BHS and BOBLAF Response to the Applicant's response to our Deadline 6 submission (REP7-006)

We comment on the responses included in section 2.5 of this document as follows:

Dwg no
Figure 2

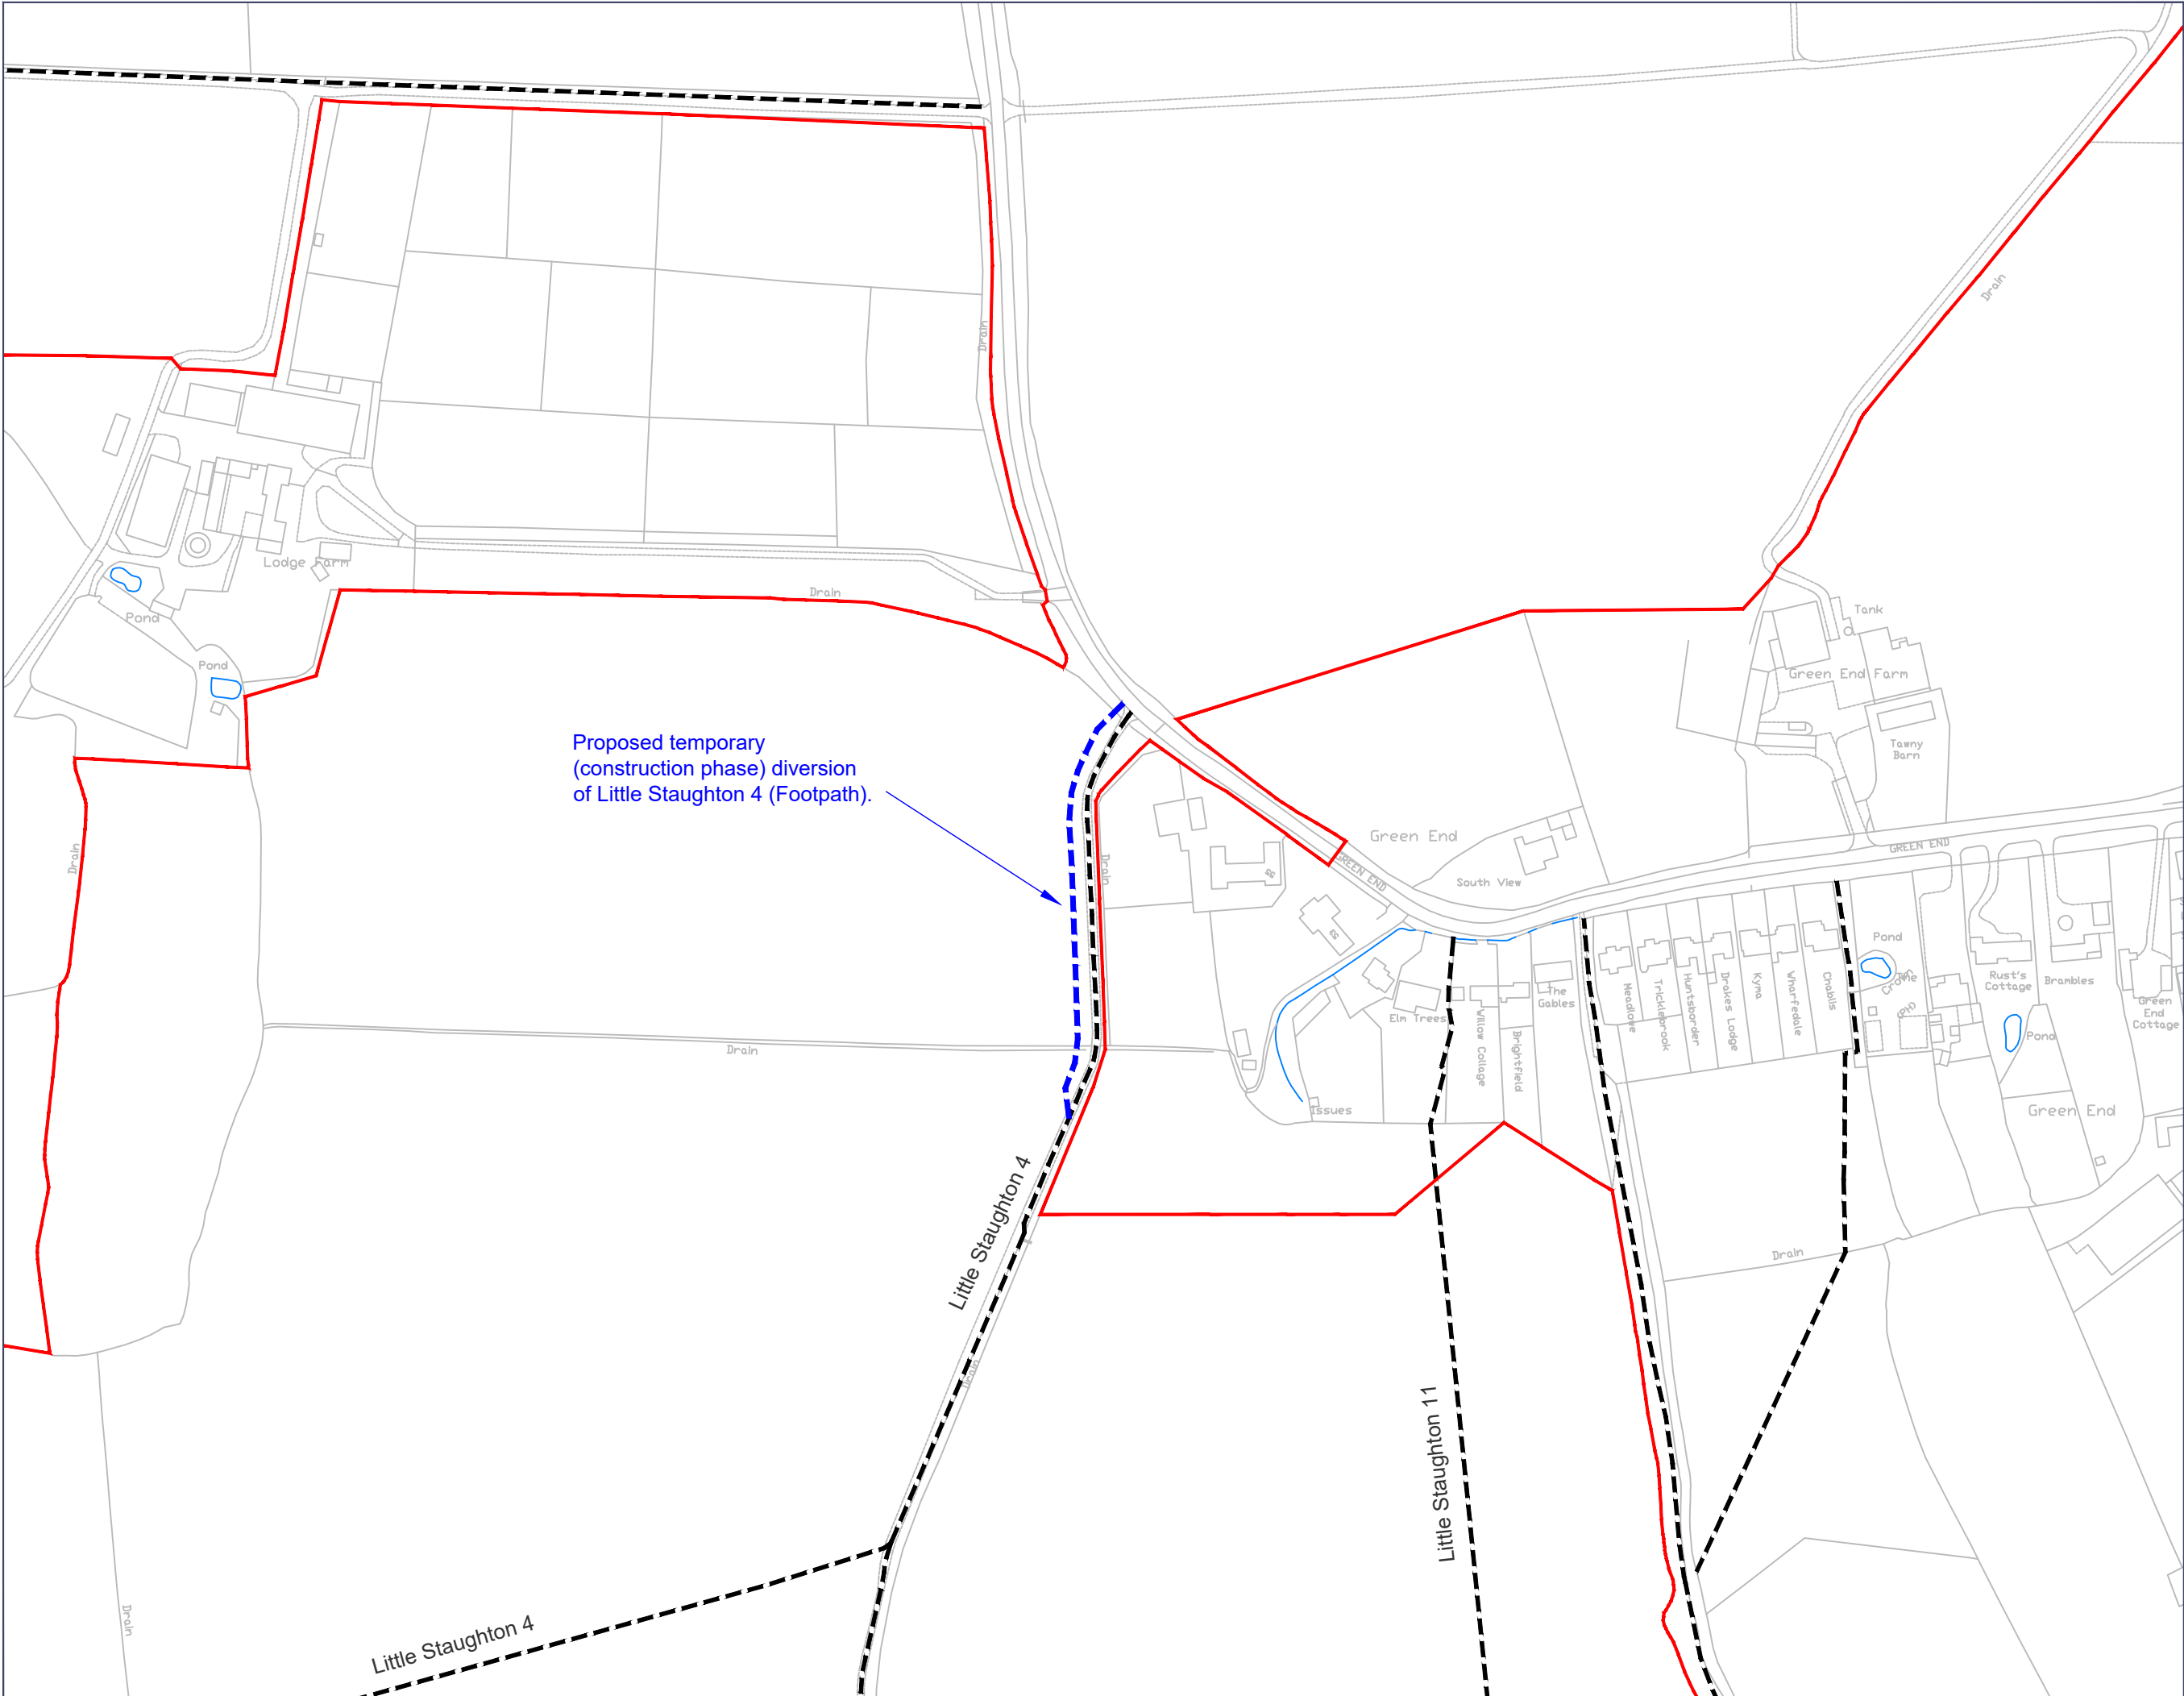
It is stated that riders from the west will be directed onto the diversion route. But Figure 2 of the draft oPROWMP shows the diversion to be immediately alongside the redline, ie immediately alongside the construction work.

BHS-D6-11: The diversion route remains uncomfortably close to the construction work and we do accept that it addresses our request for a safe and suitable diversion.
